RE: Response to Exhibition of Sydney Opera House (SOH) Building Renewal Program – Concert Hall Upgrade and new Creative Learning Centre (SSD 8663)

ATTACHMENT A: SYDNEY OPERA HOUSE BUILDING RENEWAL PROGRAM

CONCERT HALL & CREATIVE LEARNING CENTRE HERITAGE ASSESSMENT

NEW O&A INTAKE LOUVRE ON FACADE
TO BE MATCHED WITH ADJACENT
EXISTING E&A LOUVRE

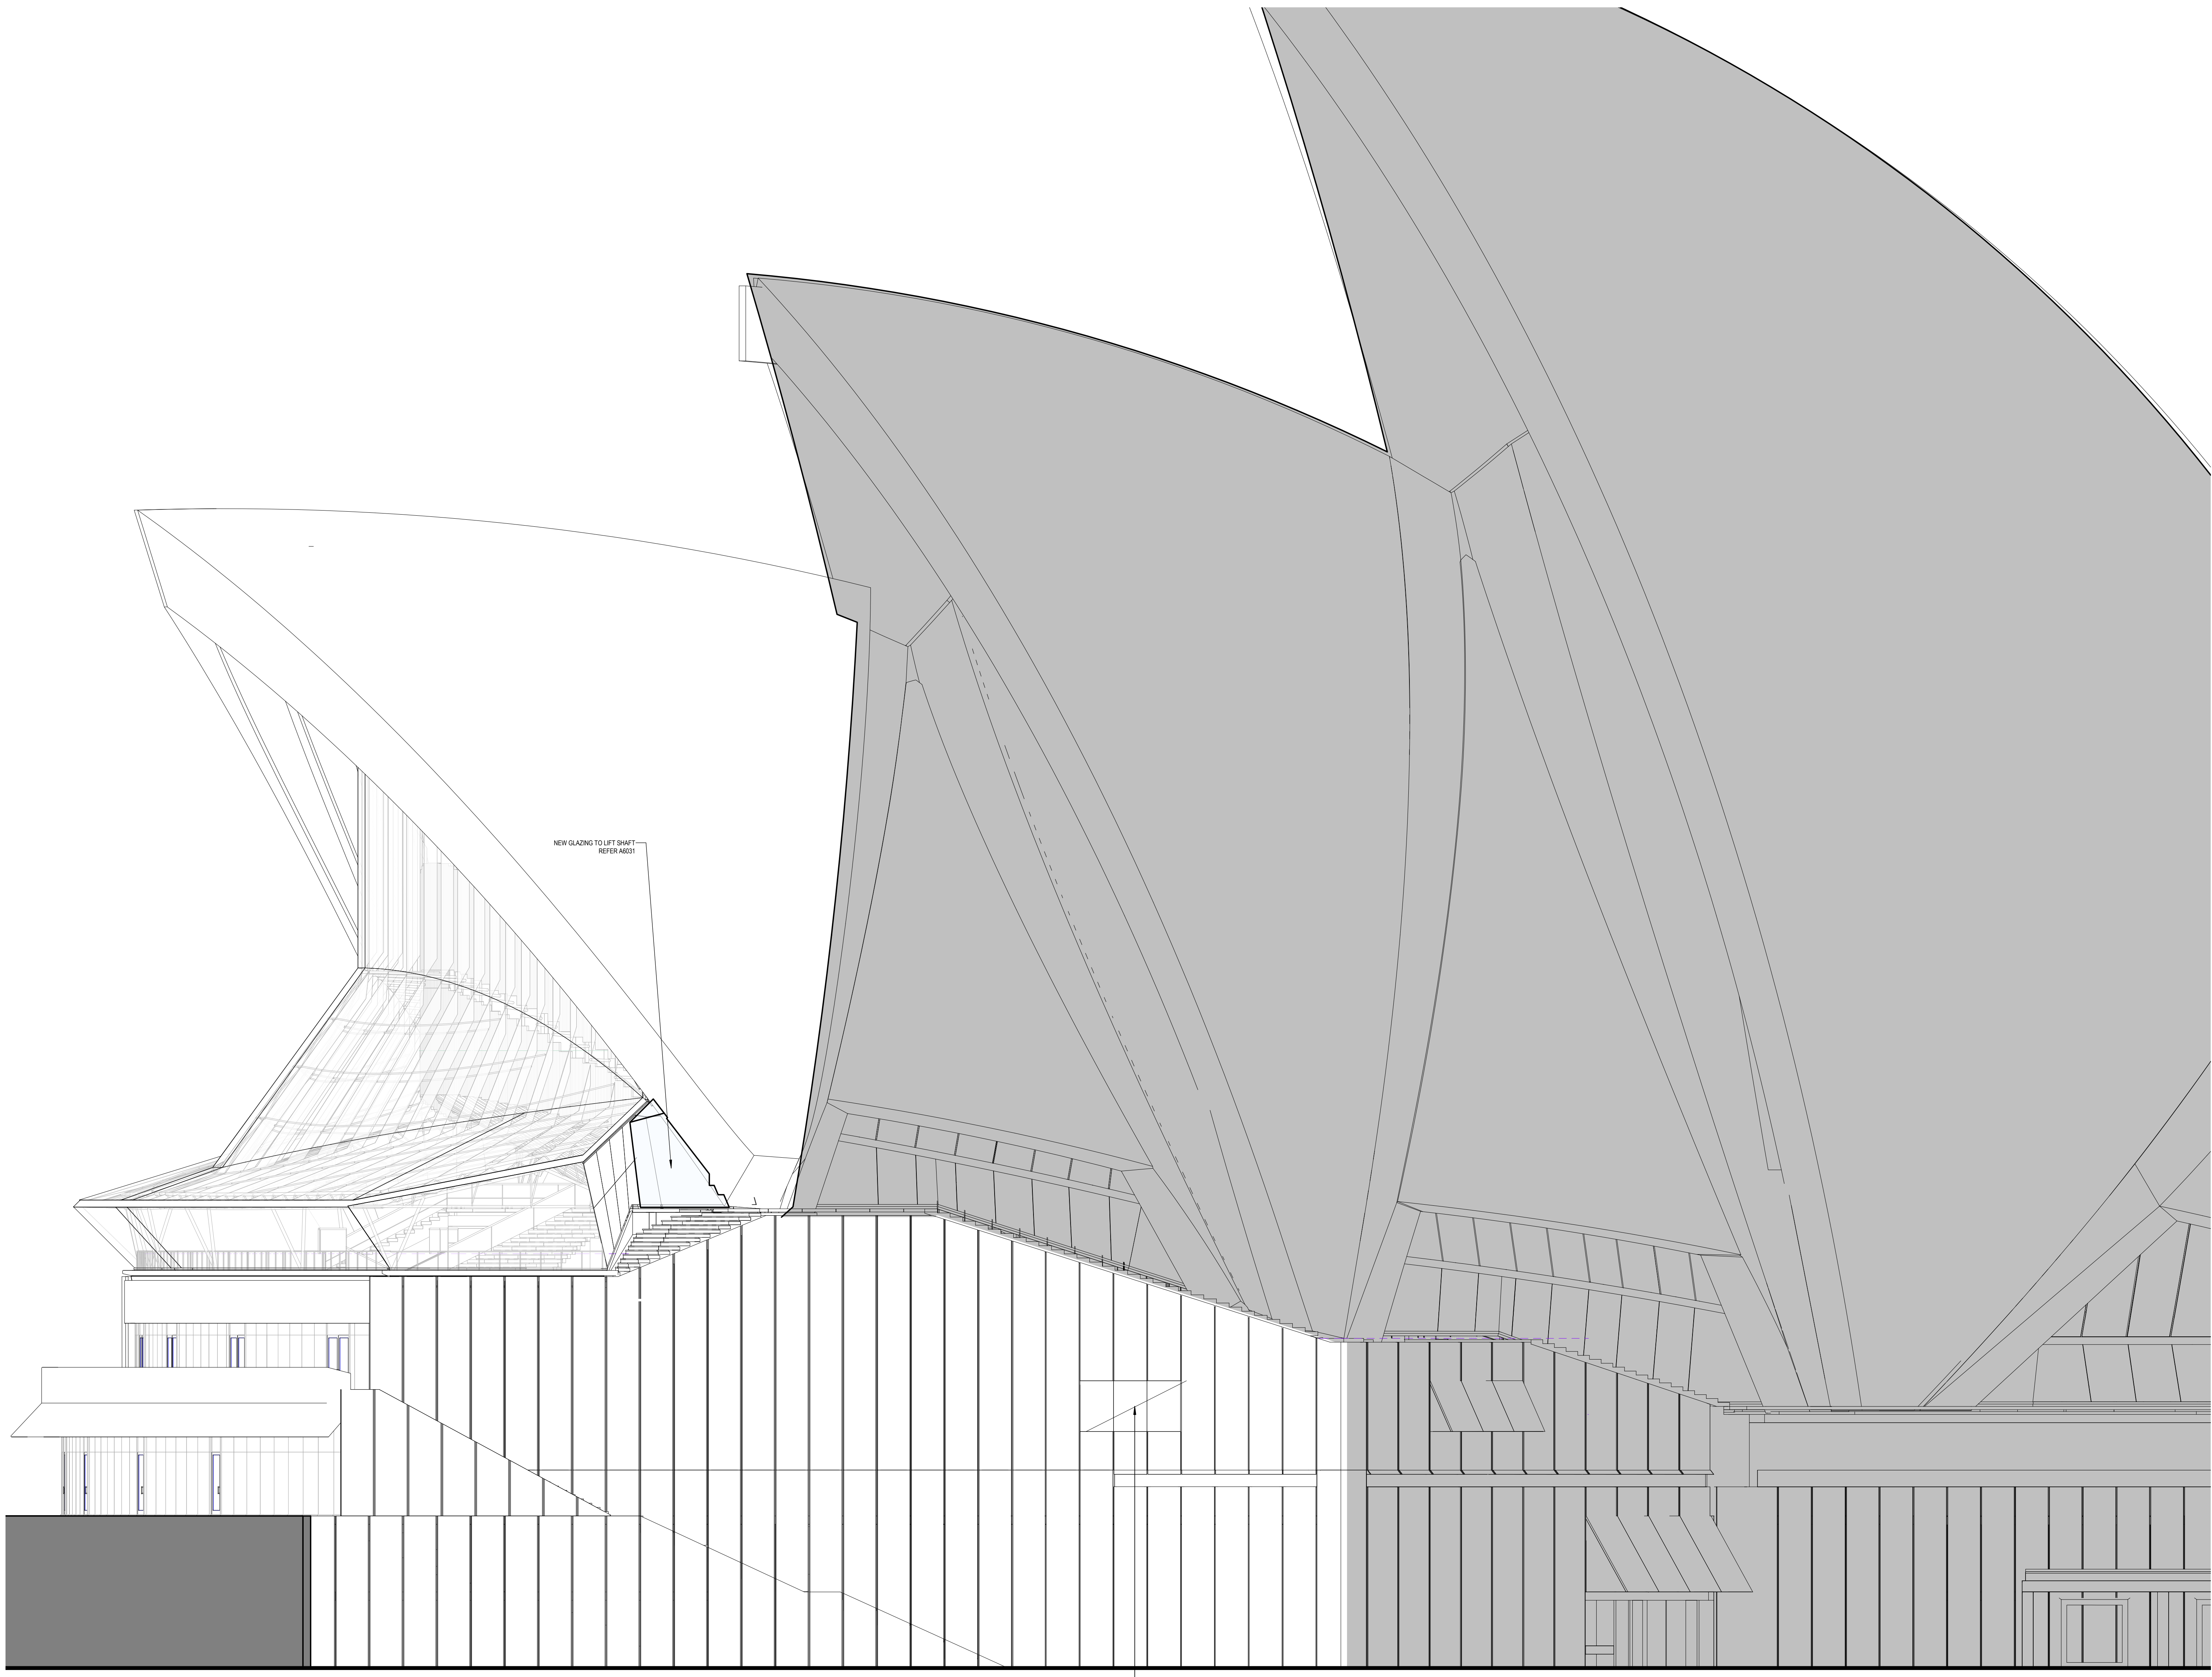
- 3.21 The proposed new penetration into the western façade of the podium to provide a new external exhaust hood opening will have an adverse impact on the solidity of the exceptionally significant podium structure in one of the most highly visible areas. Whilst a number of similar hooded openings are located on the western façade, the area of the proposed opening is within a large area of uninterrupted panels. In addition, this proposed hood is a cumulative impact which will adversely affect the dominant, solid, dramatically rampart/ shear wall. The effect includes the resulting shadow as well as the hood itself.

- 3.22 It is understood that the existing hood opening adjacent is unable to be utilised for the purposes of exhaust as this is for air intake. However, it is unclear why the proposed opening is three panels wide whereas the existing opening on the eastern side is only two panels wide. In addition, it is unclear if the location of the air exhaust adjacent to the air intake vents is acceptable and whether other locations were considered.

- 3.23 The proposed works involve the removal and replacement of three precast granite panels and penetration into the existing external concrete wall. This is a major intervention into significant fabric.
- 3.24 The relocation of the existing plantroom and the resultant demolition of several internal walls and reconfiguration of back of house spaces is acceptable.
- 3.25 The works also involve the removal and replacement of mechanical machinery/equipment. It is unclear whether the significance of this equipment has been assessed and thus the impact of removal and replacement has not been determined.

- 3.26 The Heritage Council does not support the design, location and size of the new mechanical exhaust hooded opening. Ventilation requirements should be reviewed to determine if alternative routes and outlets are feasible including utilisation of existing slots and hoods within the podium. This should be further reviewed in consultation with the Heritage Council to assess the appropriateness of this major intervention into the exceptionally significant podium wall.
- 3.27 Further research is required to assess the significance of the mechanical equipment and machinery prior to removal. This should be done by an appropriately qualified expert in consultation with the nominated heritage advisor. The results of this assessment should be considered by the Heritage Council prior to determination on relocation of the equipment and machinery.
